Dr Richard Fitzpatrick  
 BSc MBBS PhD MD  
 13304 Hume Highway  
 Sutton Forest NSW 2577  
 r.fitzpatrick@unsw.edu.au

PERSONAL SUBMISSION  
 on SSD 6334: Sutton Forest Sand Mine  
 21 June 2018

QUARRY ACCESS ROAD LAYOUT

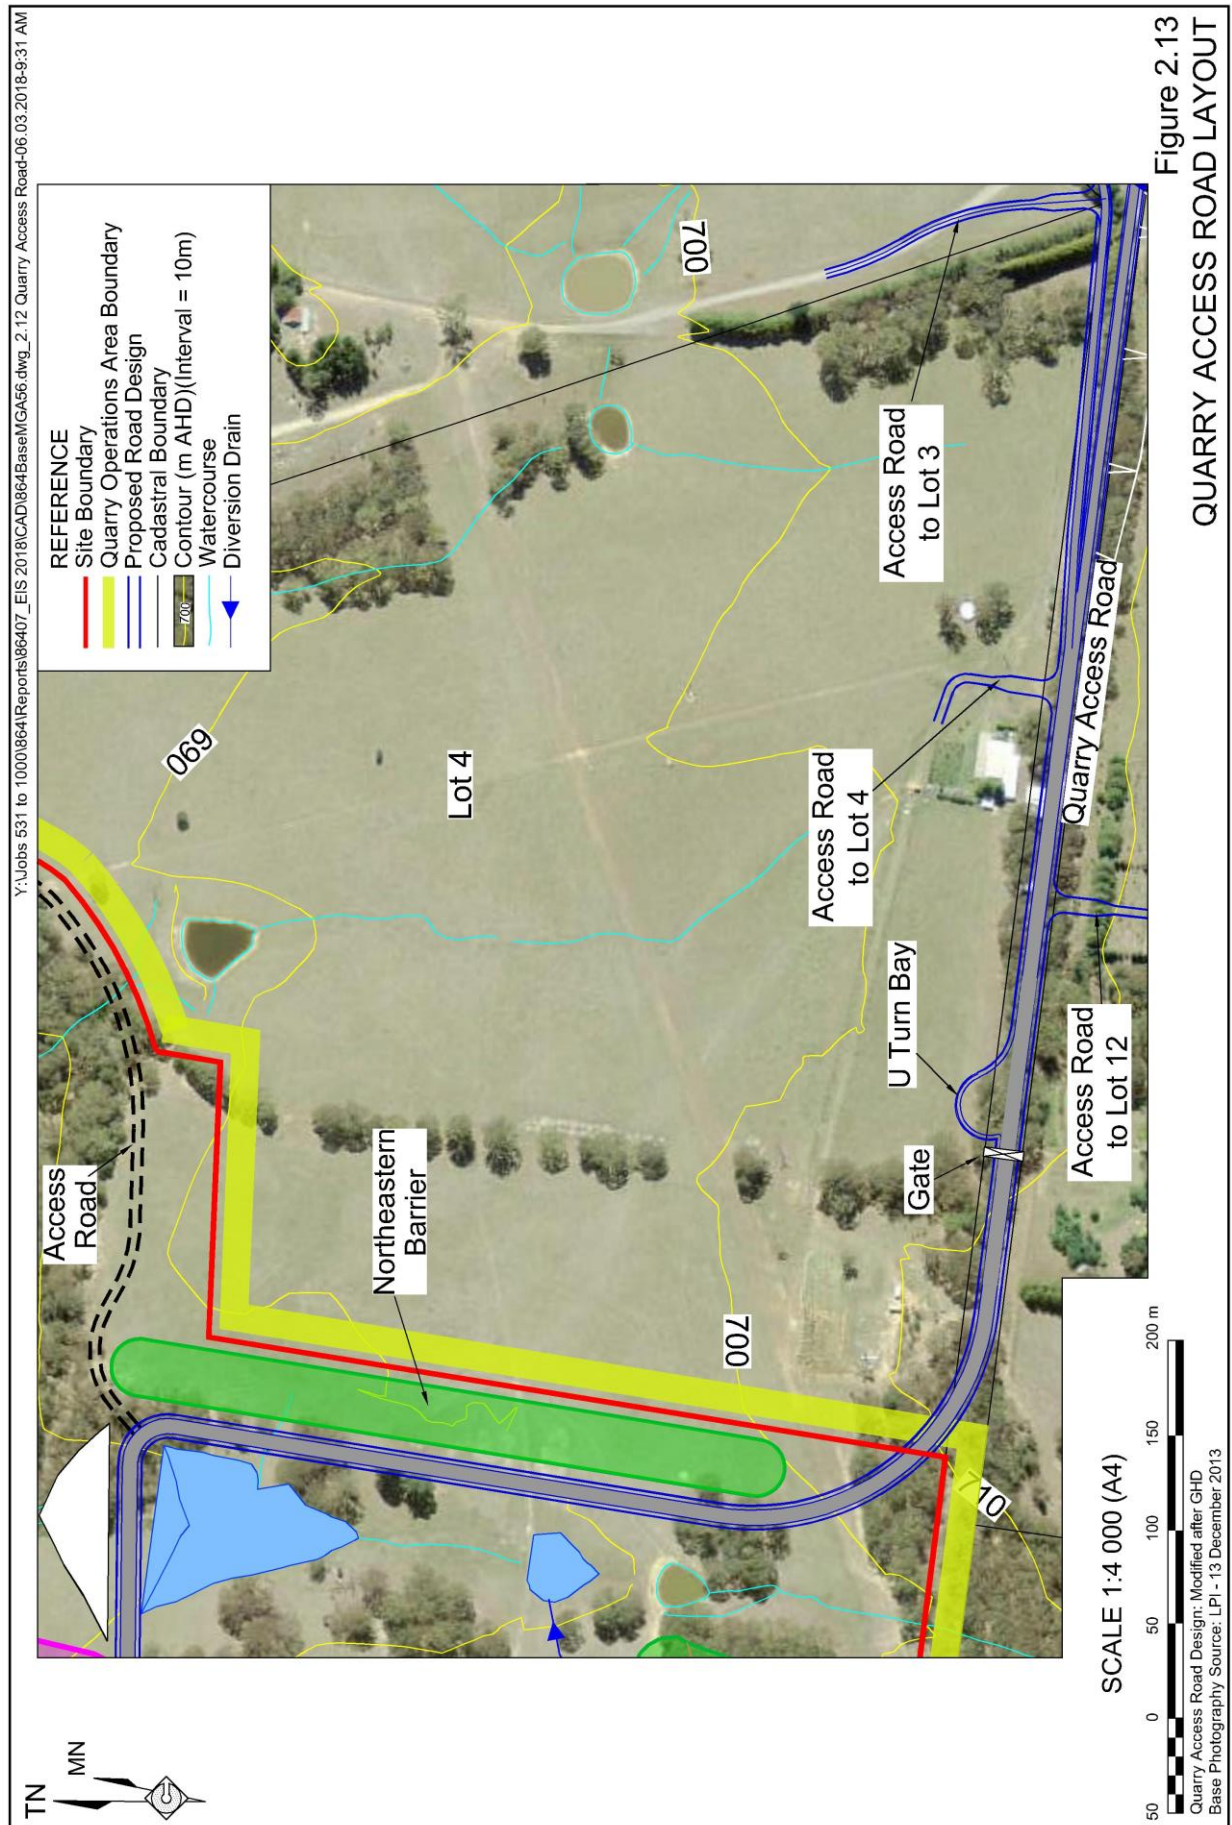
2. First, the current access to our property will be blocked. *There has been no consultation on this.*
3. The embankment of the support road at the interchange to the mine access road encroaches our property boundary, indicated on the map plan to be ¼ acre (Figure Page 5-11 of EIS). This will remove our historical front entrance and many of our trees, several being memorials to past family. *There has been no consultation on this.* **Under no circumstances will we give permission to access or acquire our property.**

4. The proposed mine access road has a concrete barrier wall, up to 3.8 metres high, running along most of the length of our boundary (presumably to appease us by sound mitigation and blocking the view of trucks). *There has been no consultation on this.*

5. They provide us road access through an opening in the barrier wall and a road that passes through our irrigated orchard. This will require the removal of our orchard crop trees and irrigation system.

7. The barrier wall will lock us in with no other exit off our property. Our gates to the property to the north are our escape route. This is Category 1 Risk as identified in the *Wingecarribee Shire Council Bushfire Prone Map (2011)*. In the event of bush fire or other emergency, made more likely by this mine, we have no exit. This is sloppy and neglectful planning.

9. The barrier wall of up to 3.8 m in height is not high enough to exclude the view of trucks as our house (primary view lounge and kitchen) is elevated above the siting of the wall. Primary school geometry shows that trucks will be exposed by up to 1 m directly in front of our house

and 1.5 m in the right of our view – only a vehicle less than 2.6 m in height will pass unseen. The barrier wall would have to be 5 m high for large trucks to pass unseen.

16. There is no plan described for water effluent from the access road. The lowest point of the road is adjacent the residence on Lot 1. A drain would need to be taken across the property to the distant dam to manage that volume of water.

**Figure 4** shows the conceptual layout of the Quarry Interchange.

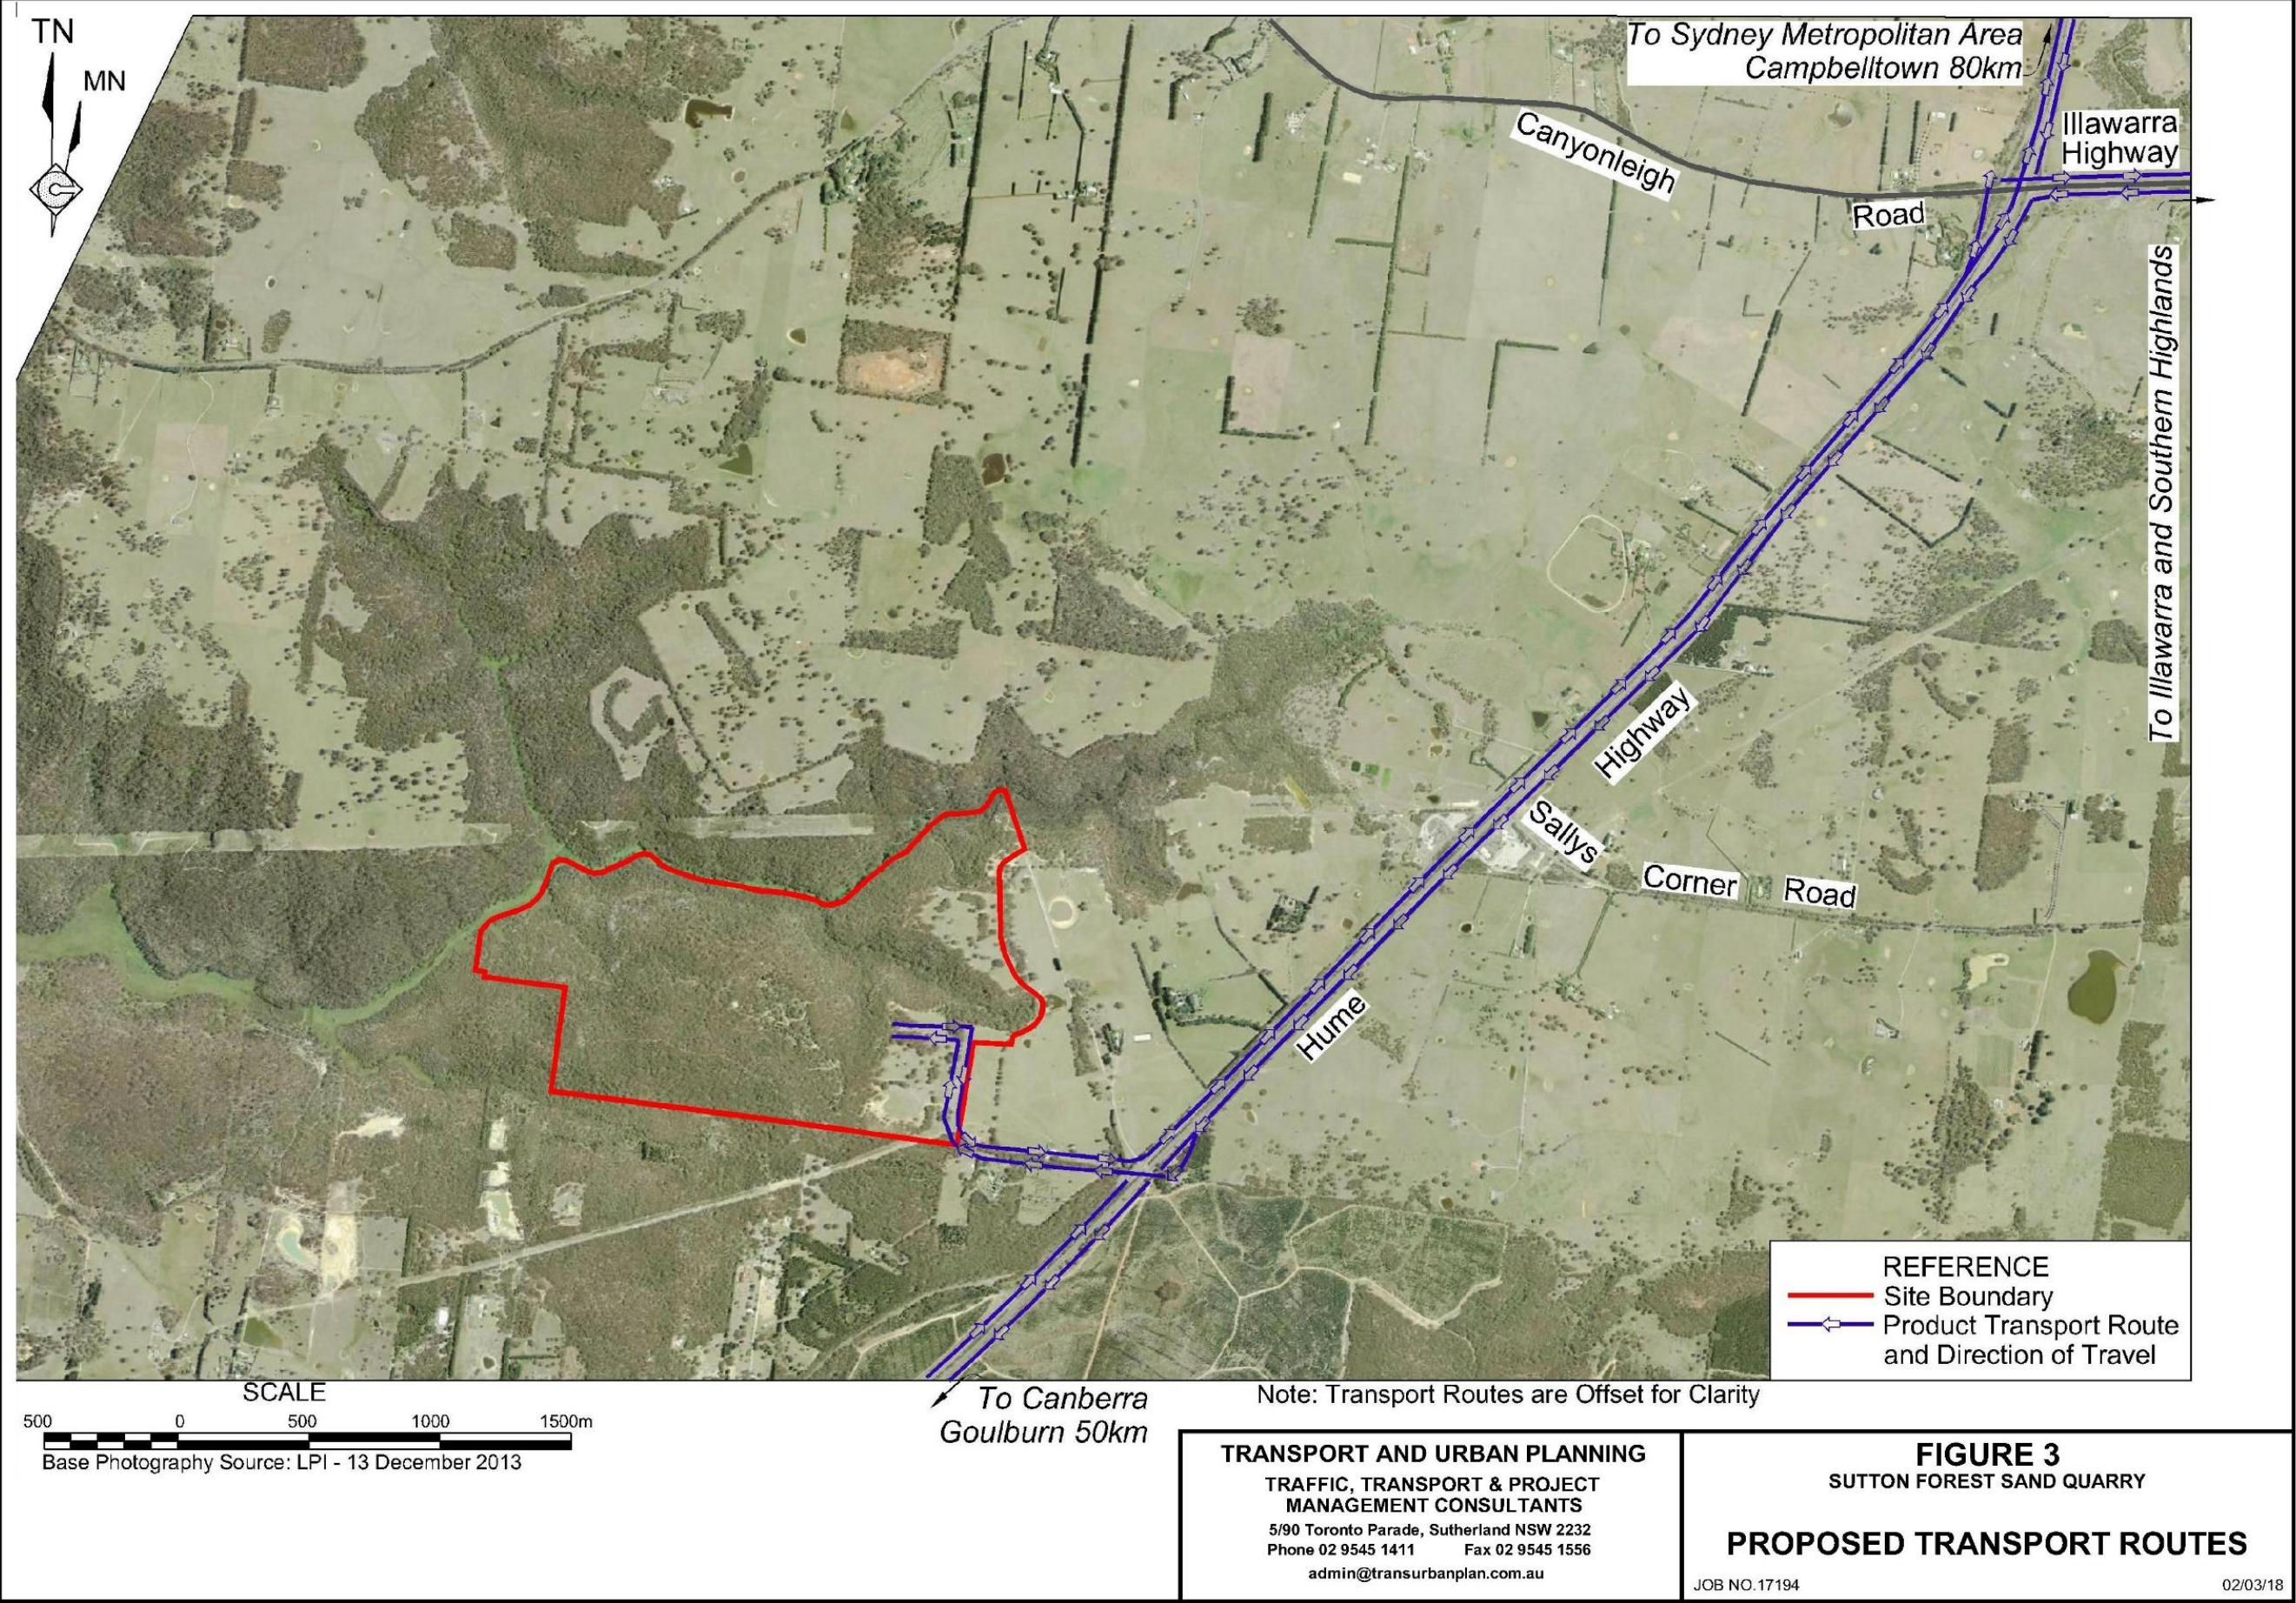
Between this proposed new junction at the mine access road and the Sally’s Corner road exit is already a treacherous stretch of road as cars coming from the south do not get a view of the service centre until they reach the hilltop at this point. They then start to move left and slow. This new access road junction will take the distance between the two slip roads down to 500 metres (16 seconds drive time), making it the closest pair of slip roads on the Highway from Sydney to Albury. With this volume of trucks attempting to gain speed and move right merging with vehicles slowing and merging right, there will be serious vehicle crashes.
